**REQUEST**

Current Zoning: NC (neighborhood center), N1-D (neighborhood 1 - D), and O-6(CD) (office, conditional)  
Proposed Zoning: CAC-1 (EX) (community activity center 1, exception)

Approximately 2.839 acres bound by the south side of Central Avenue, west side of Piedmont Street, north side of Sunnyside Avenue, and east side of the Independence/I-277 Ramp.

Central Avenue Multifamily, LLC

SHEET NUMBER  
RZ1-00

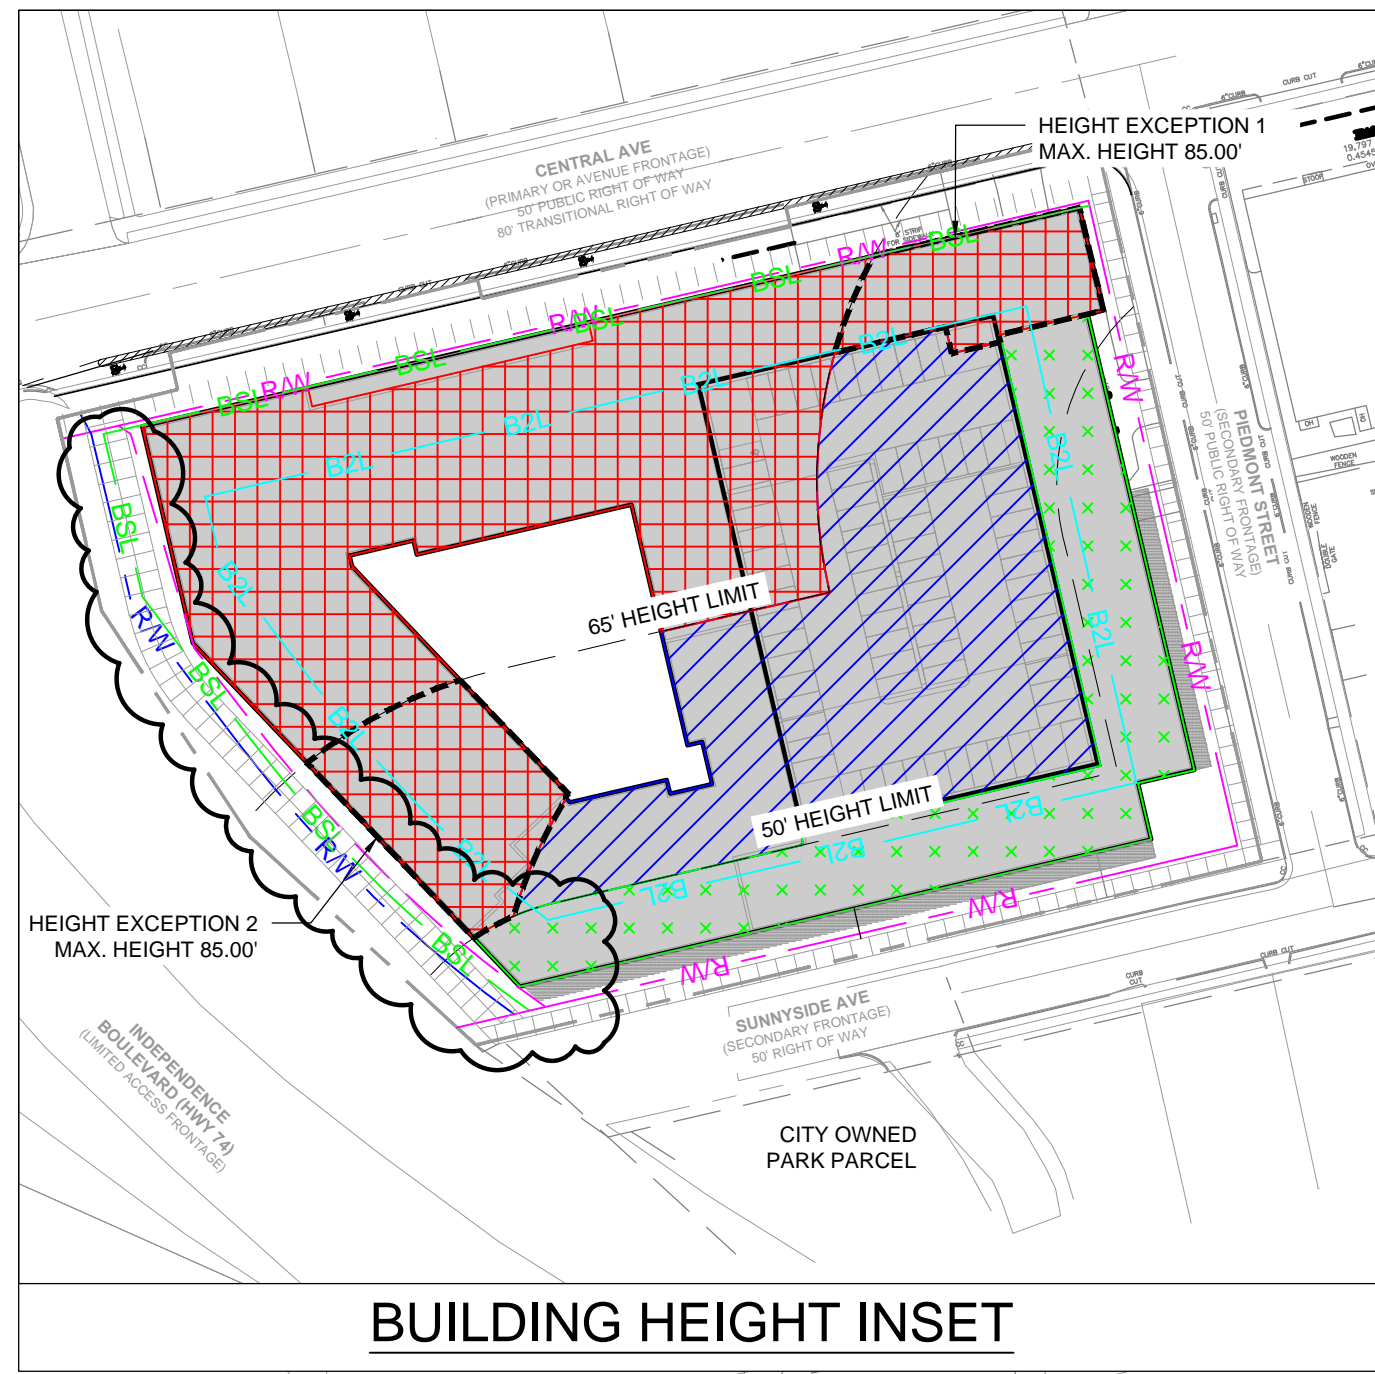
1. Revise the site plan to clearly show the limits of CATS infrastructure.
